RE: FRASERS BROADWAY - BLOCK 2 AMENDMENTS

I refer to the proposed detailed design changes for the proposed building known as Block 2 on the Fraser's Broadway site.

**SIGNAGE PERSPECTIVES**

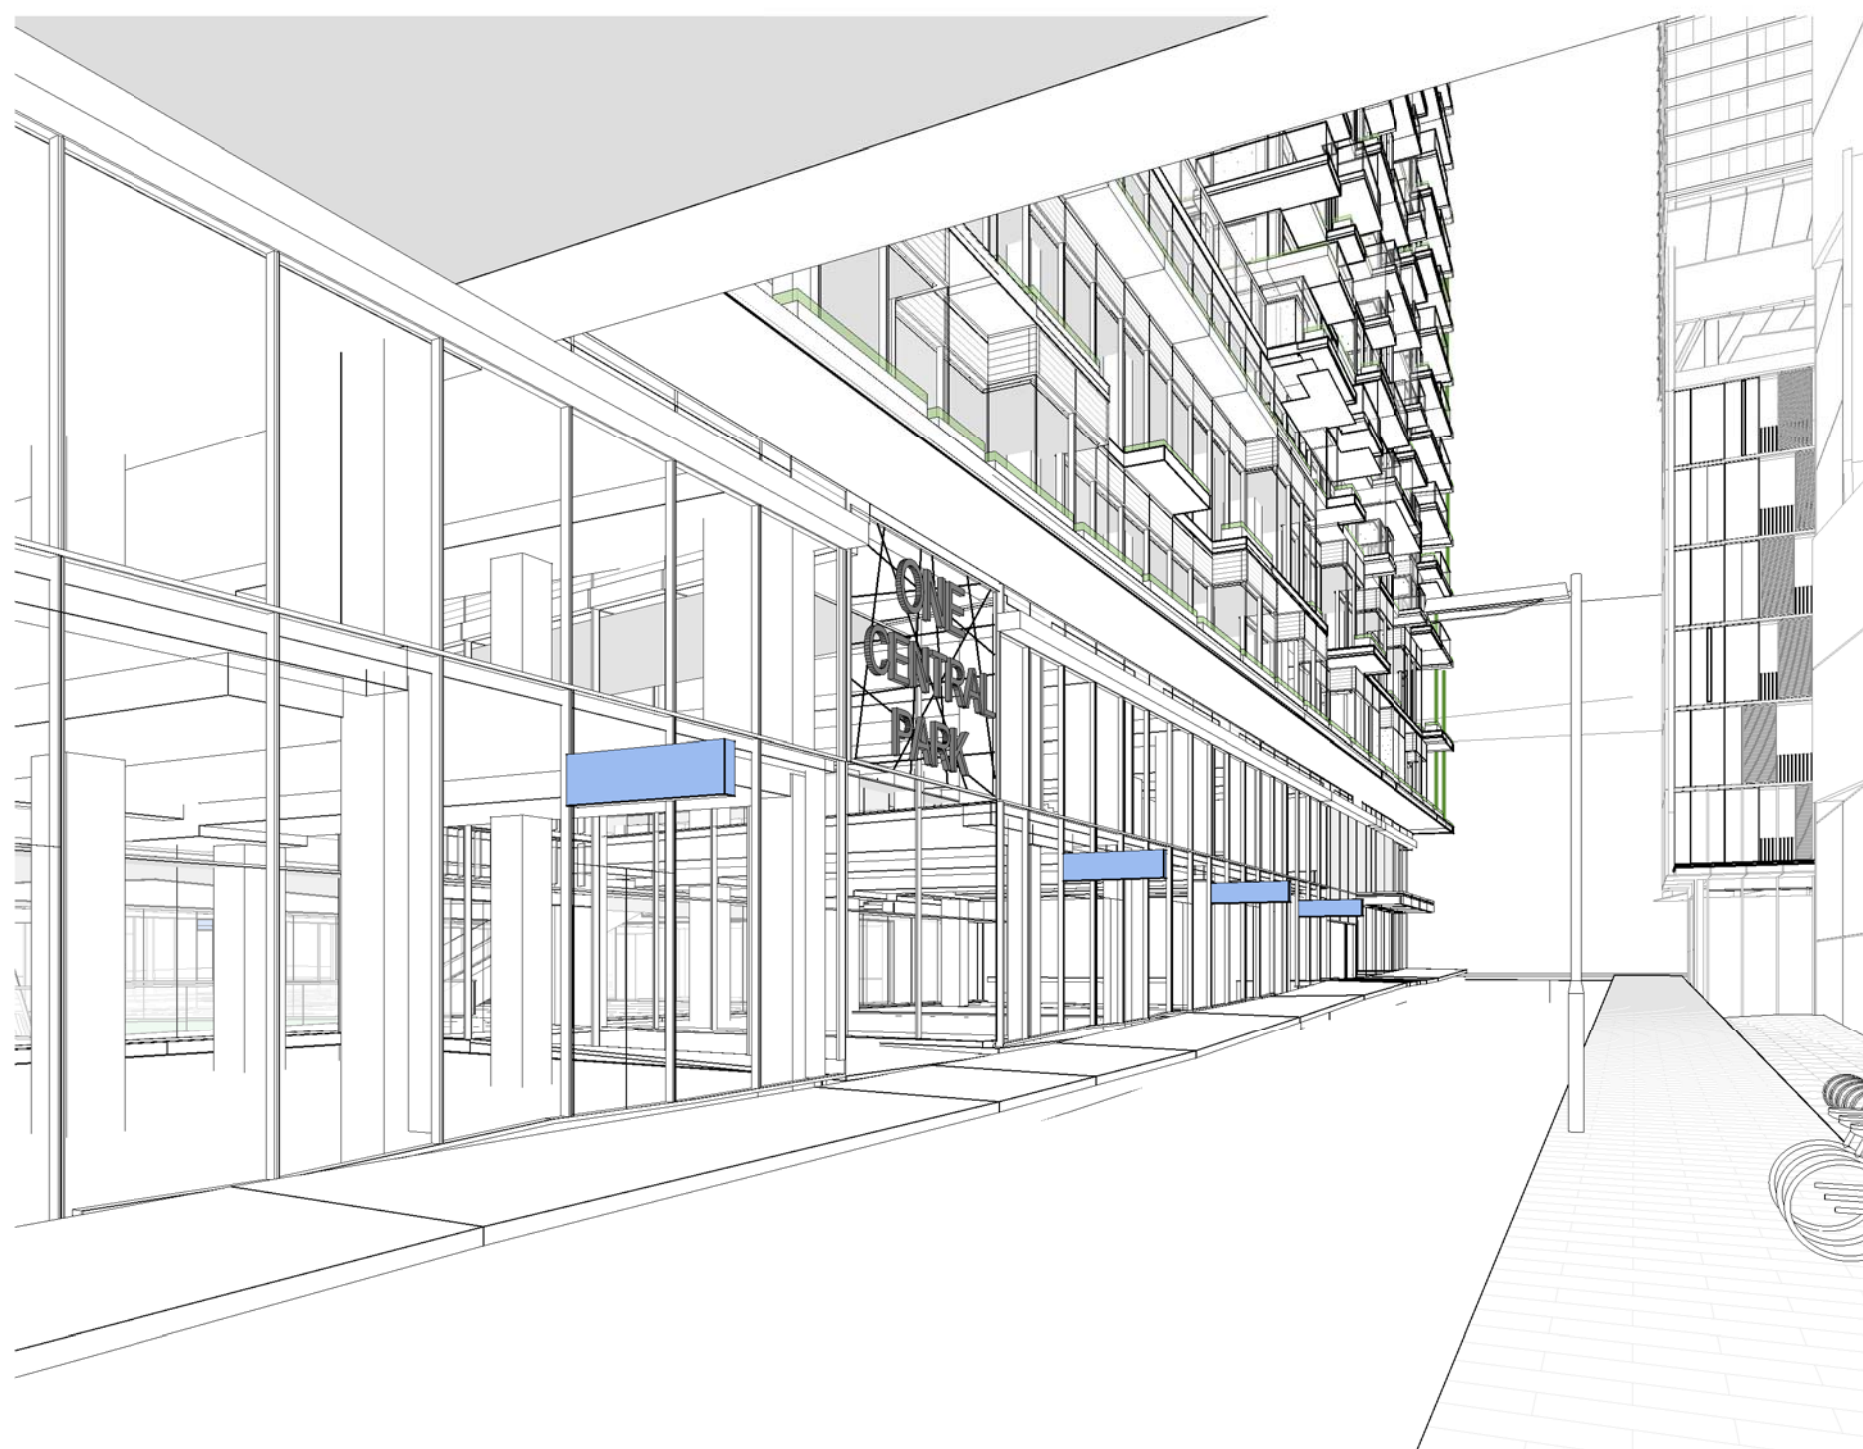
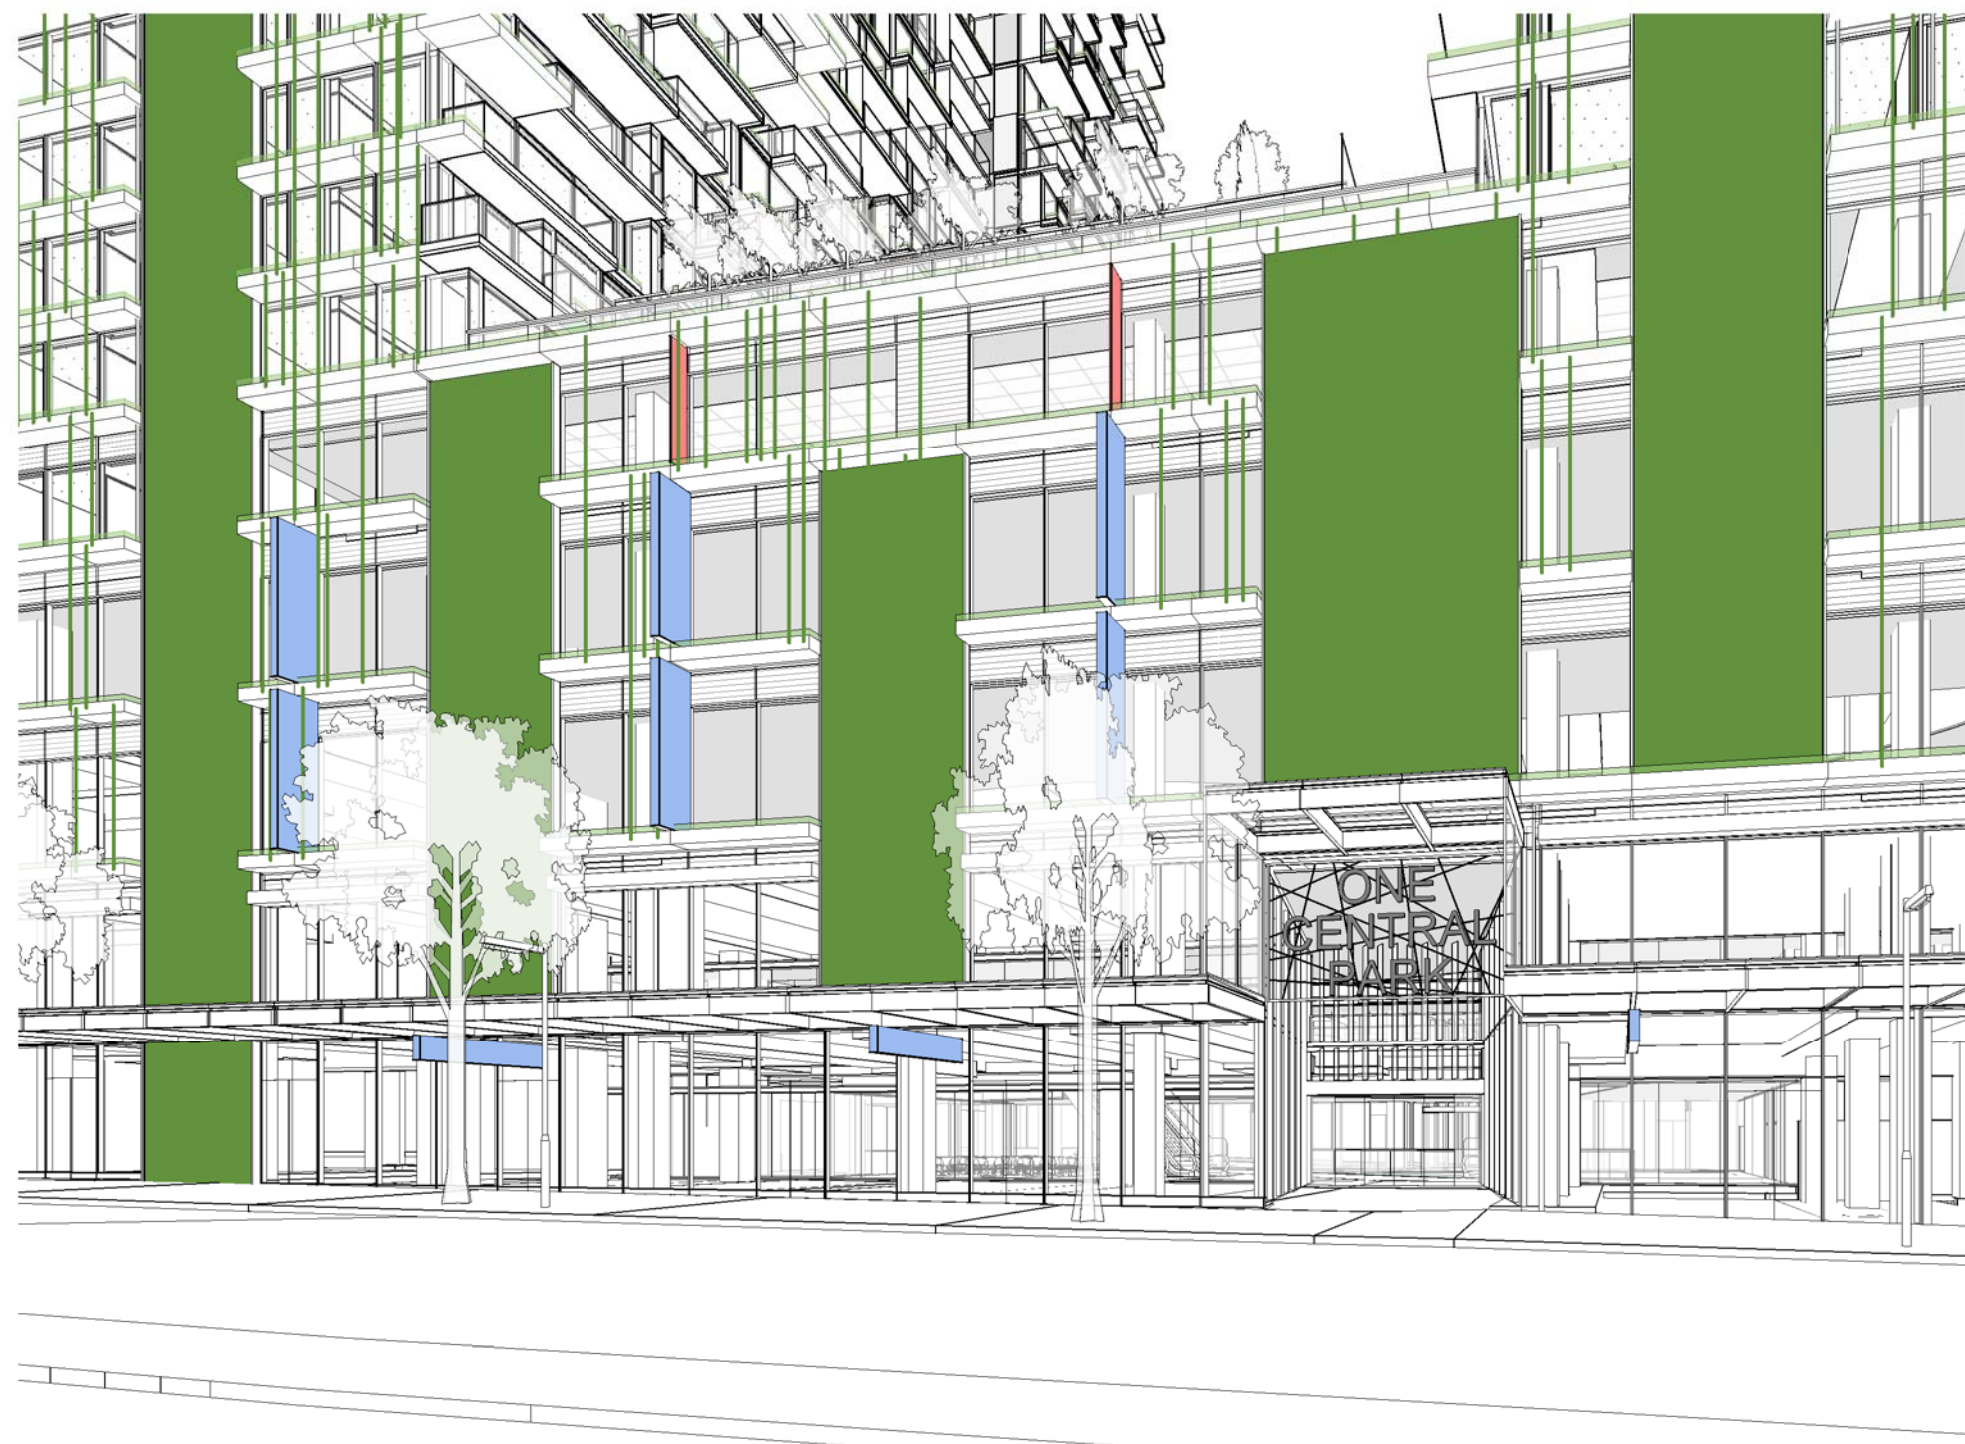
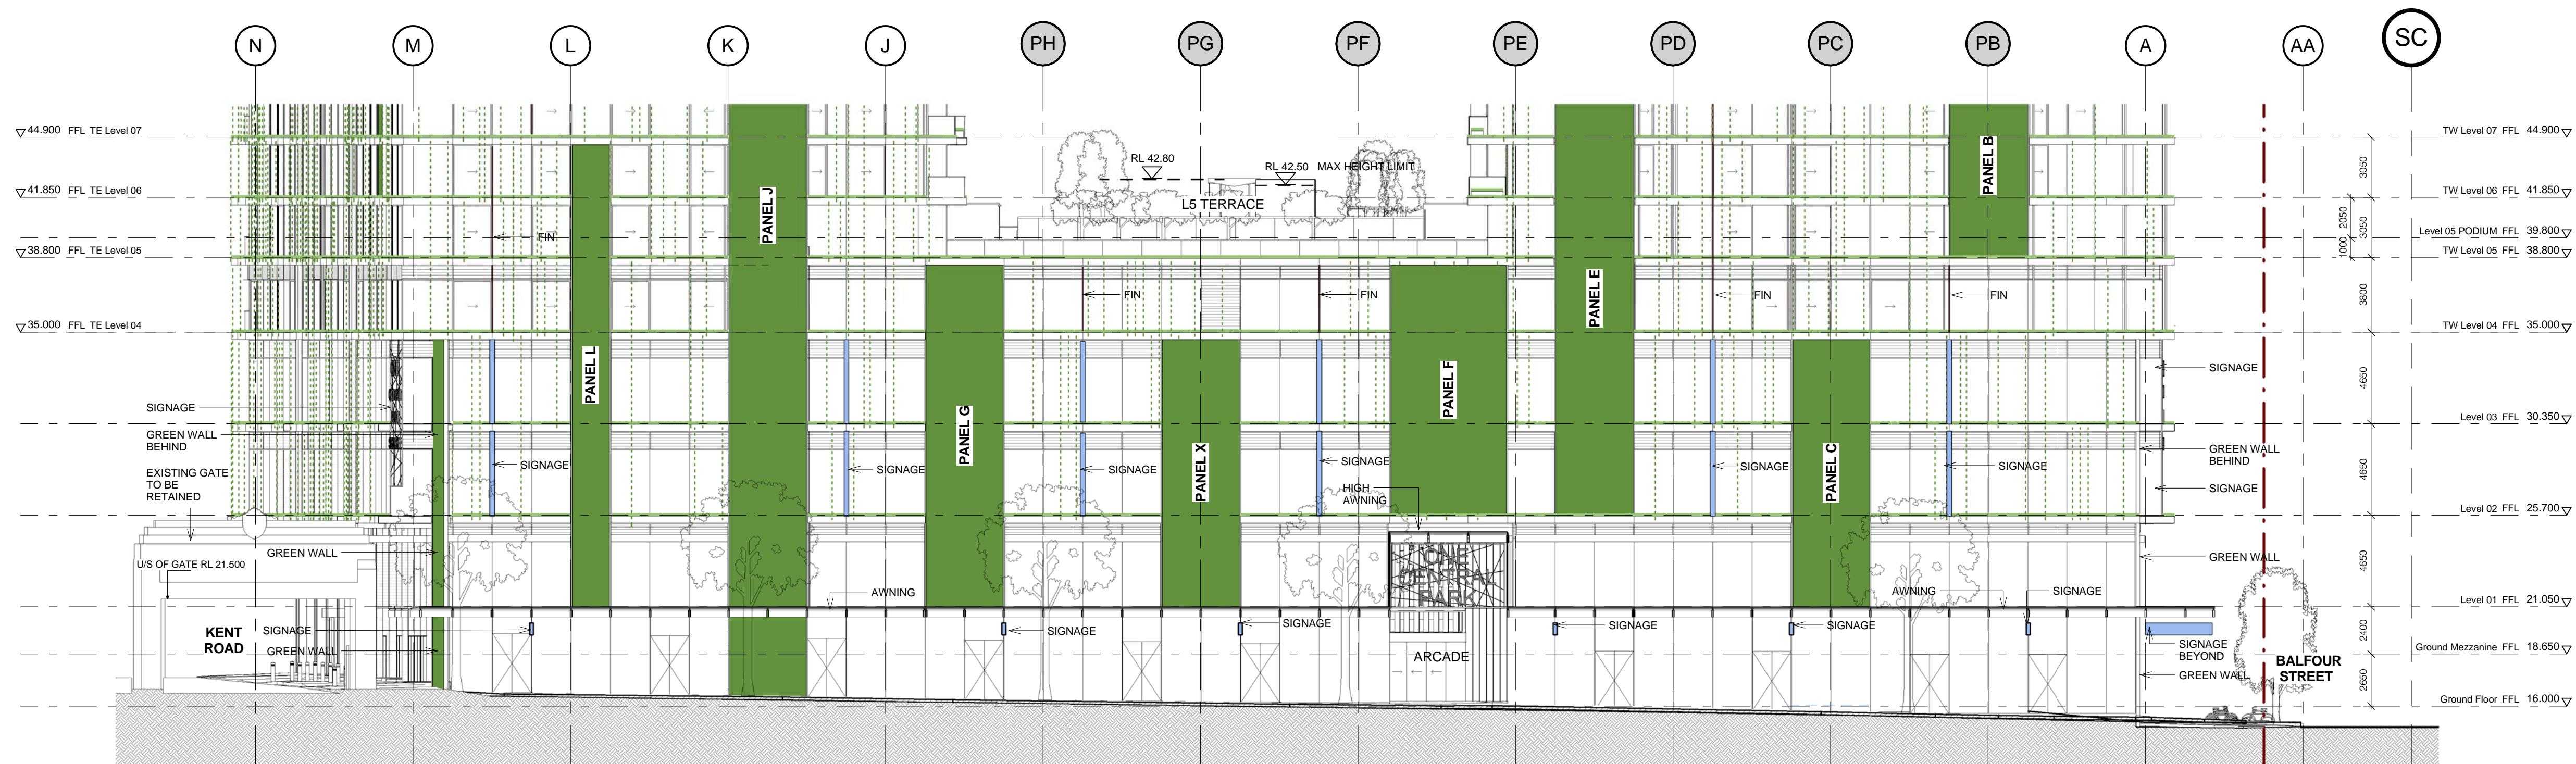
There is a vertical signage panel proposed to sit forward of the recess in the north east corner, and it is understood that this identifies a zone for a future mesh sign panel or a sign with individual letters. It is considered that the bottom line of the proposed signage zone should be raised by approximately half a storey from the level shown in the drawing, so that the Gateway is seen in all views with a backdrop to the vegetated wall, and not with a backdrop of a signage panel. This will result in an overall reduction in height of the signage zone to ensure the Gateway will be viewed with an appropriate backdrop, and is necessary to ensure the Gateway remains as prominent as possible, given its small scale in the streetscape.

In summary, it is considered that the proposed changes are acceptable provided that the bottom line of the signage panel is raised approximately half a storey from the level shown in the drawing, to enable the Gateway to be viewed with a backdrop to the vegetated wall.
